# ENG-SF19009-V3-FDR-redlines.pdf Markup Summary

**Subject:** EPC ENG Review  
**Page Index:** 1  
**Date:** 5/13/2020 11:12:17 AM  
**Author:** dsdrice  
**Color:** ■  
**Layer:**  
**Space:**  
**Page Label:** 1

N:\118500\DRAWINGS\CONSTRUCTIVE\DWG\27-28-30-118500-CHANNEL_REV.dwg, 4/5/2020, 2:14:46 PM, 1:1

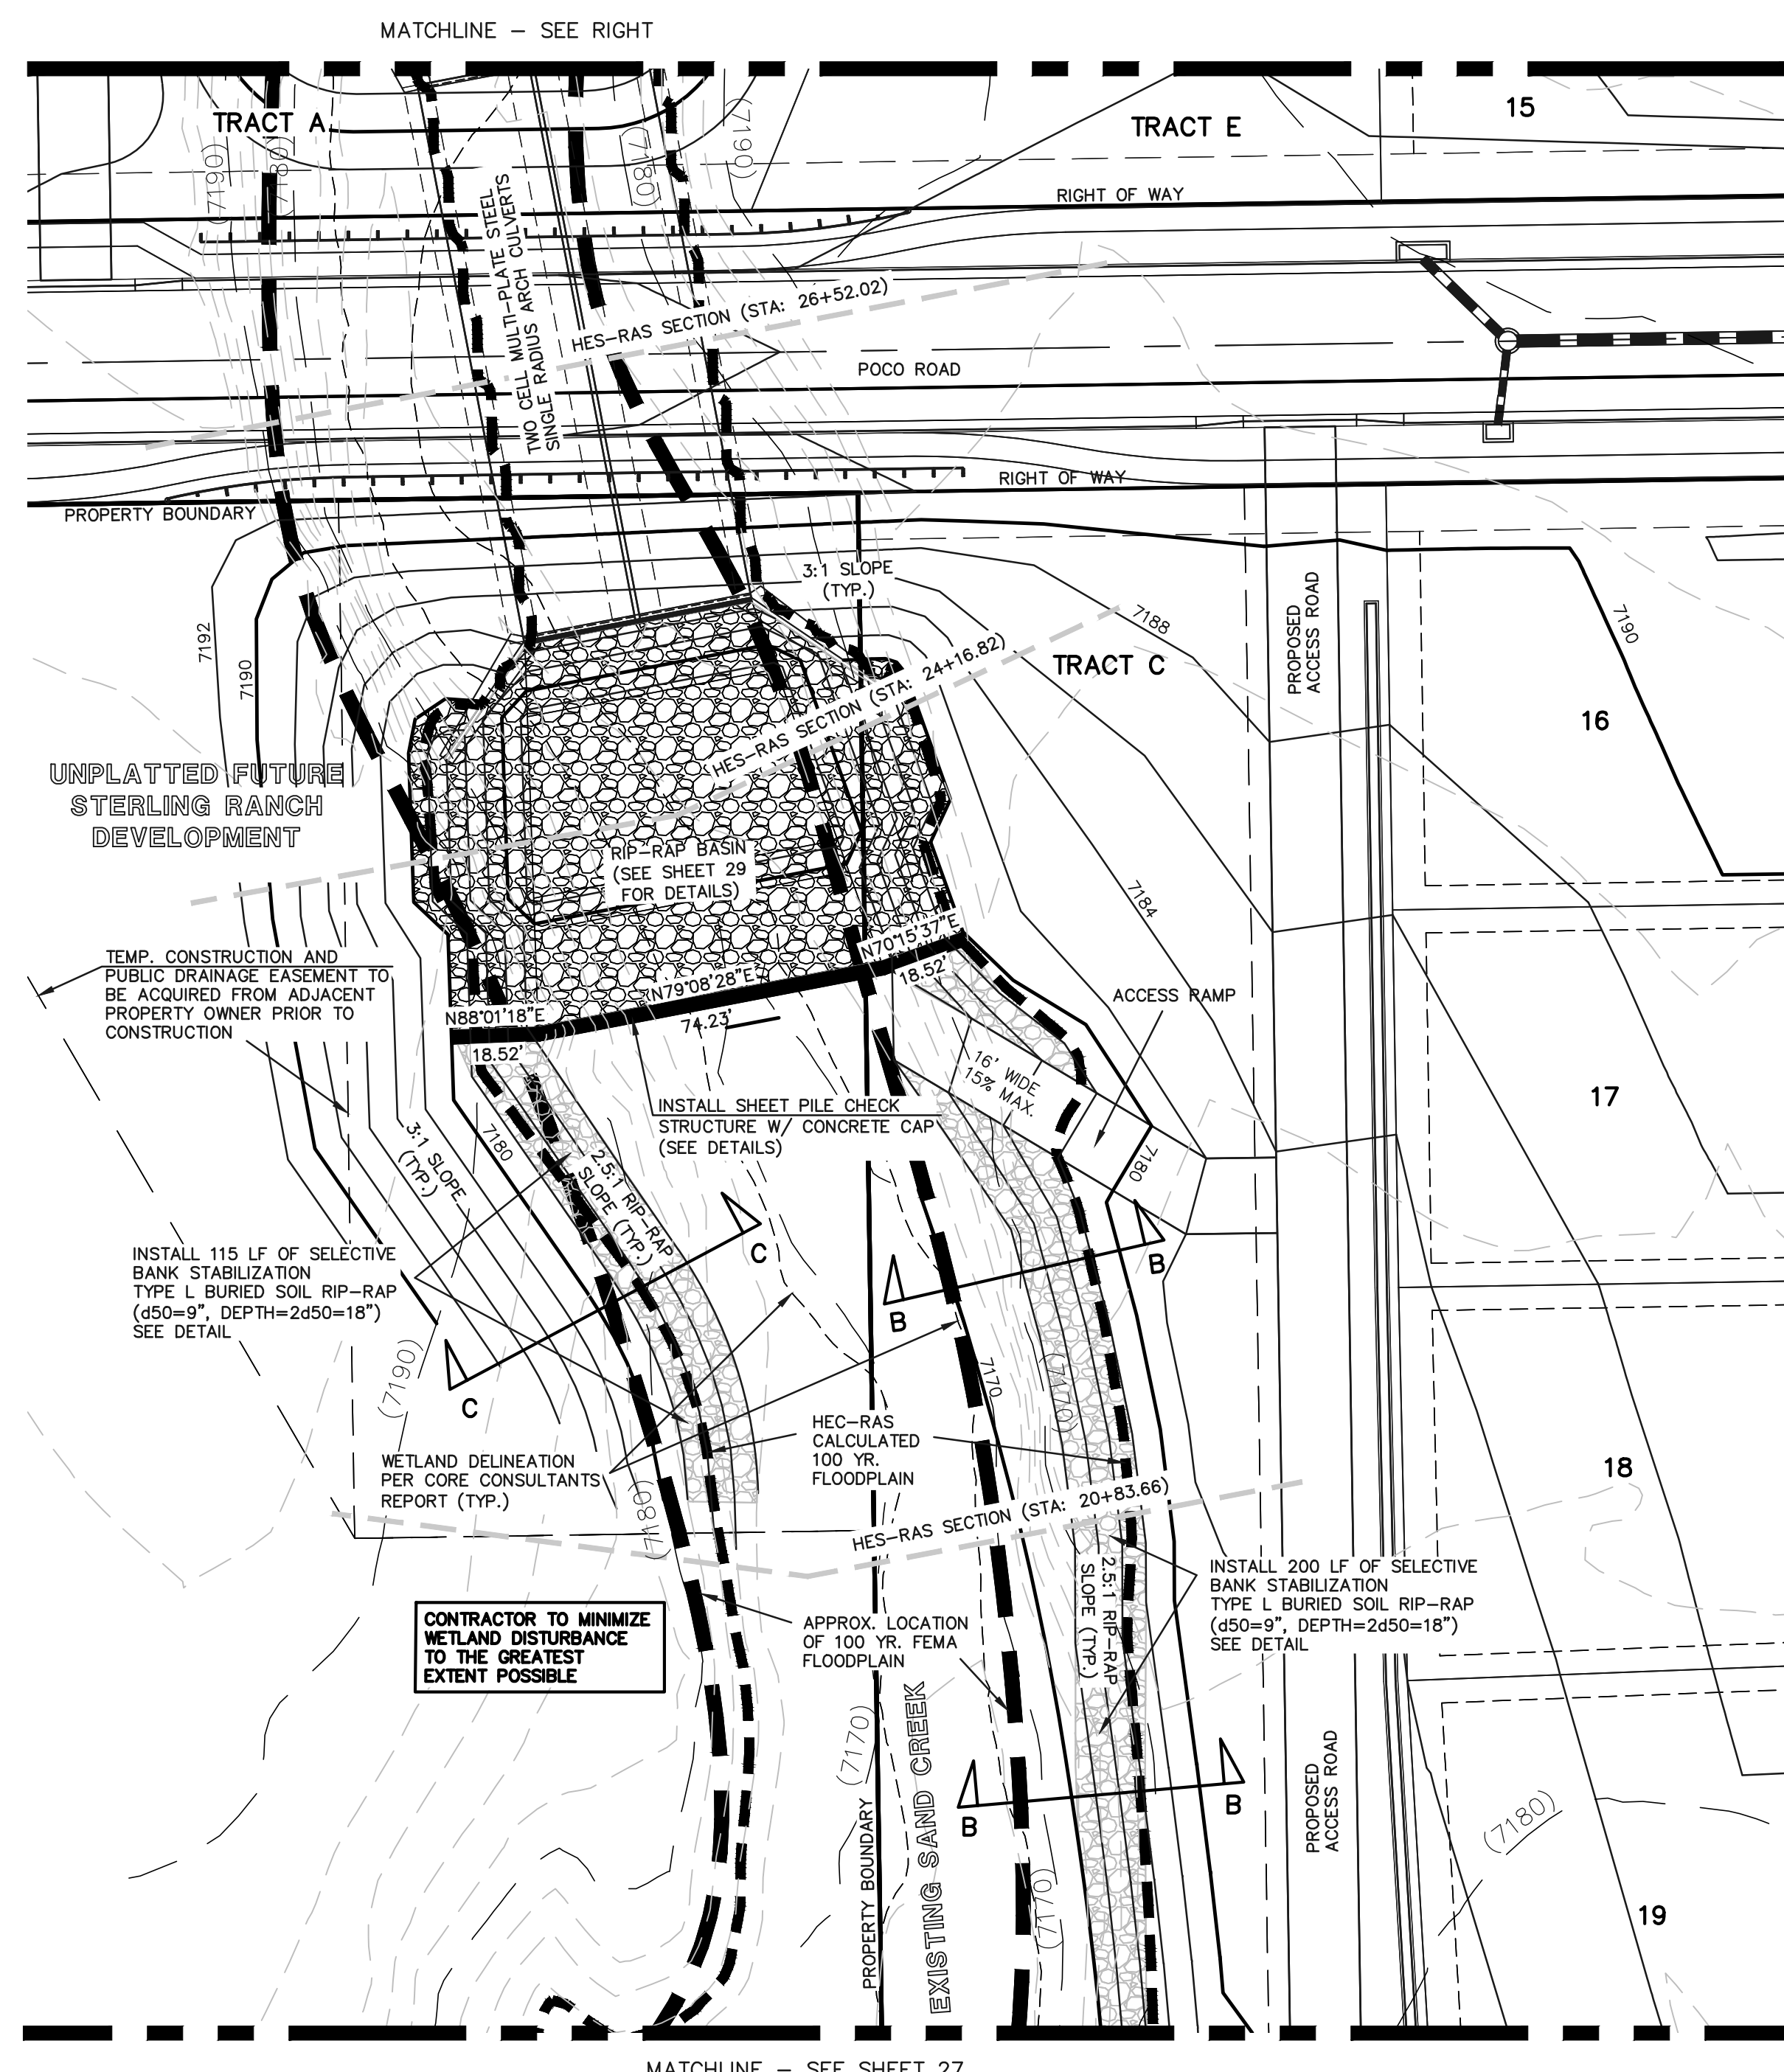
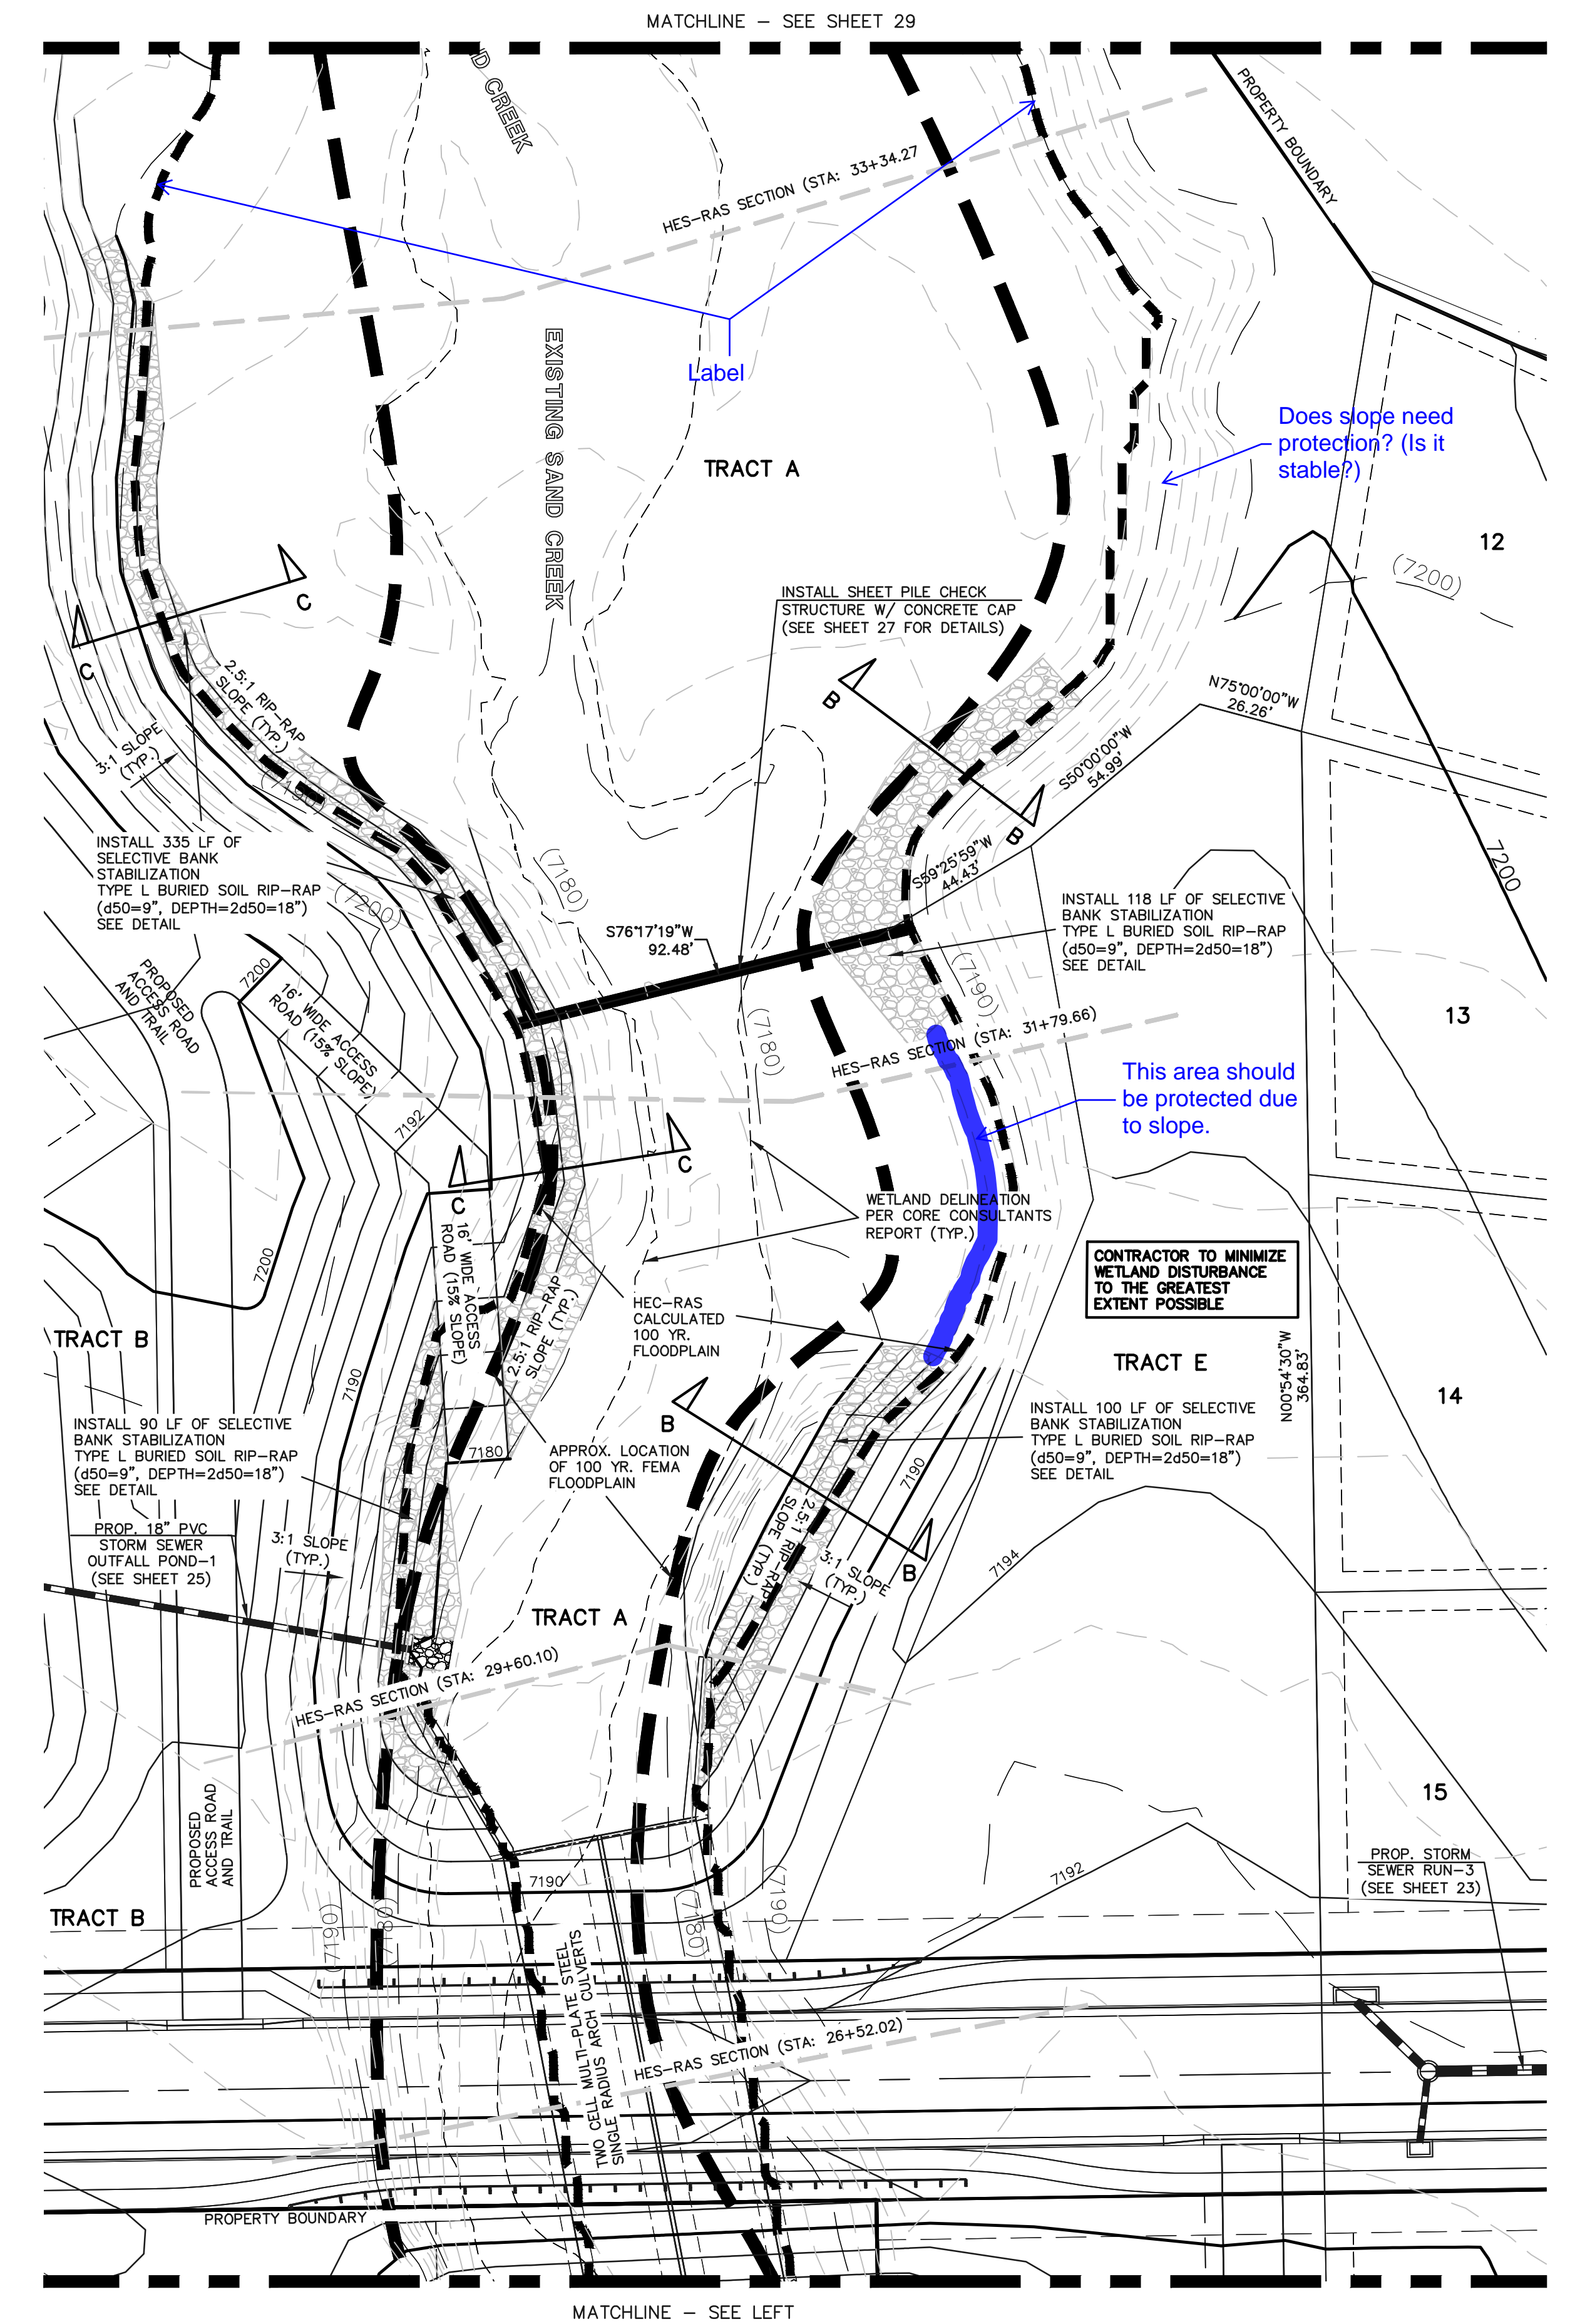
It appears that bank stabilization should be provided here adjacent to proposed lots.
